# ENG-SF22023-R1-TIS.pdf Markup Summary

**Subject:**  
**Page Index:** 15  
**Date:** 8/19/2022 3:04:20 PM  
**Author:** dsdrice  
**Color:** ■  
**Layer:**  
**Space:**  
**Page Label:** 15

Falcon Meadows at Bent Grass Filing 4 (LSC #S214333)

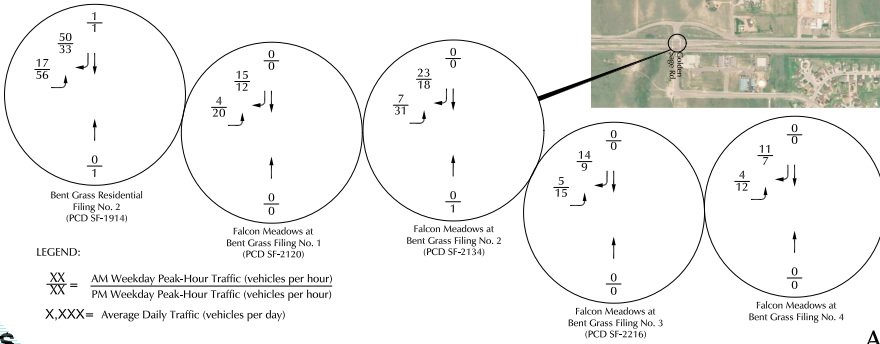
Add this intersection

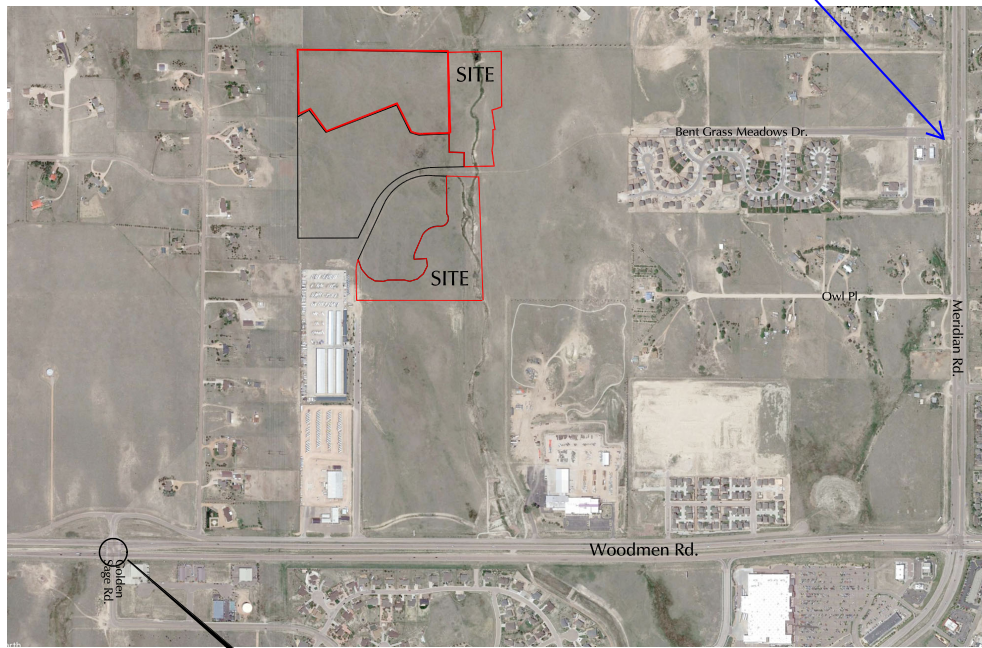
Add this intersection
